Current Zoning: MUDD-O (mixed-use development district, optional)  
 Proposed Zoning: MUDD-O SPA (mixed-use development district, optional, site plan amendment) with 5-years vested rights

Approximately 14.28 acres located on the north and south side of Baxter Street, east side of East Morehead Street, west of Pearl Park Way.

The petition proposes a site plan amendment to approved rezoning petition 2021-092.

Atrium Health, Inc.

Exhibit A – General Sign Locations

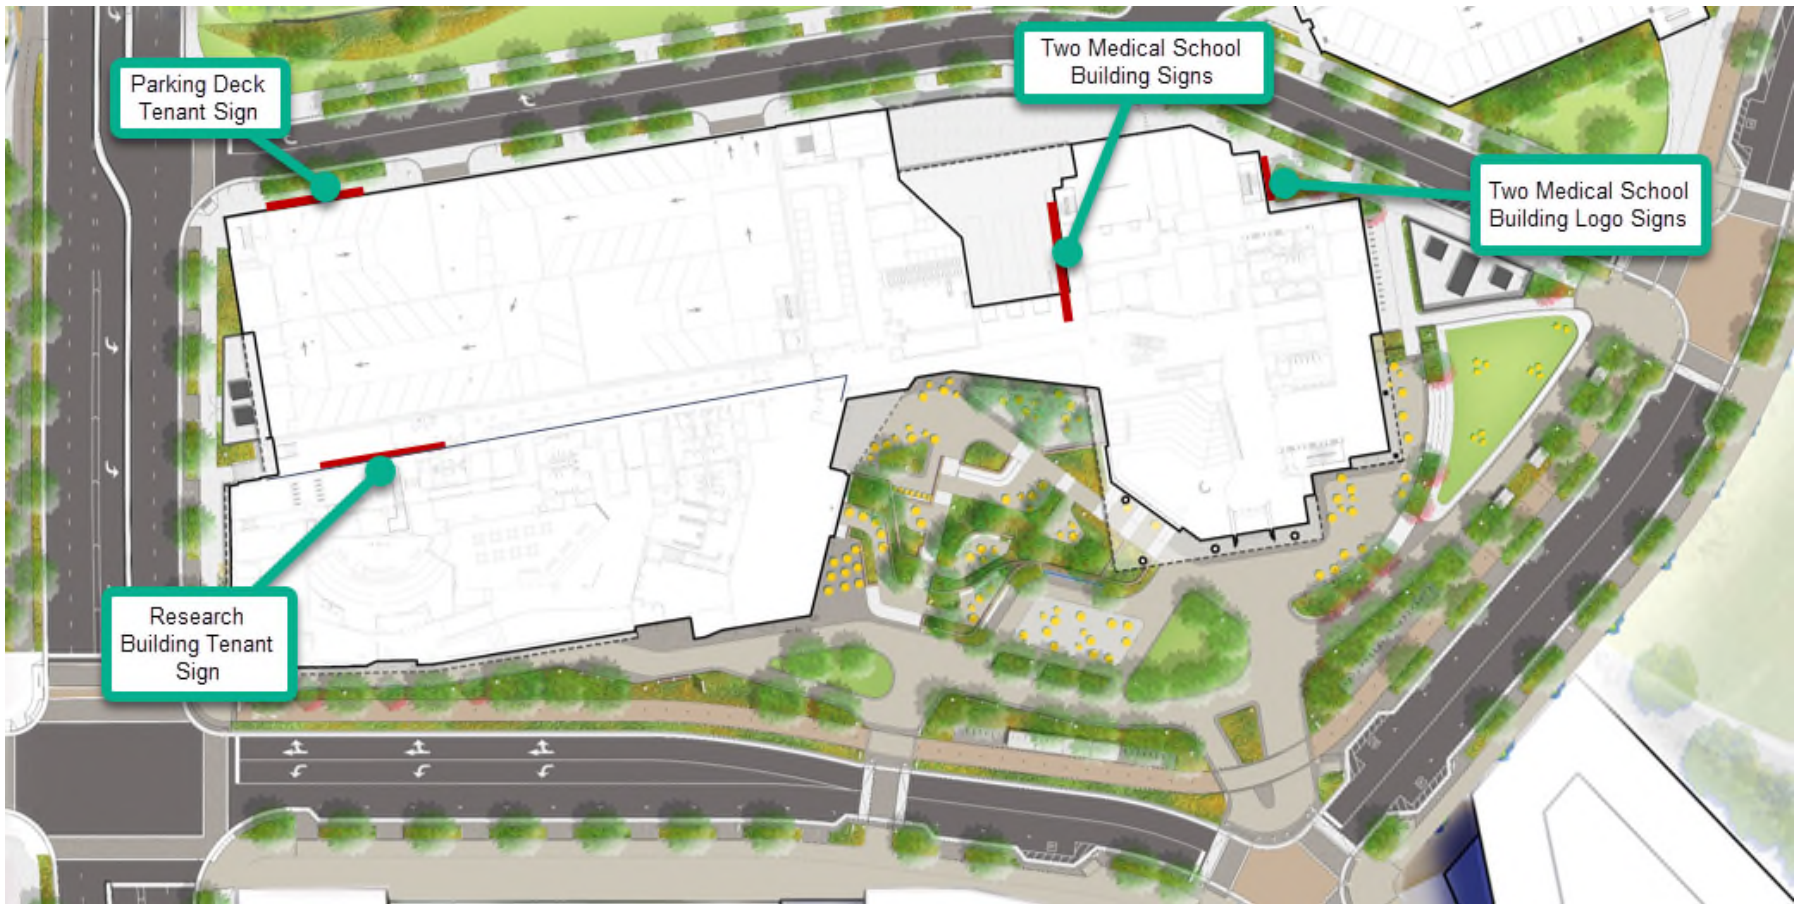
2. ~~Clarify whether the signs proposed in the optional provisions meet the definition of skyline signs or wall signs. Modify as needed.~~ **Addressed**
-
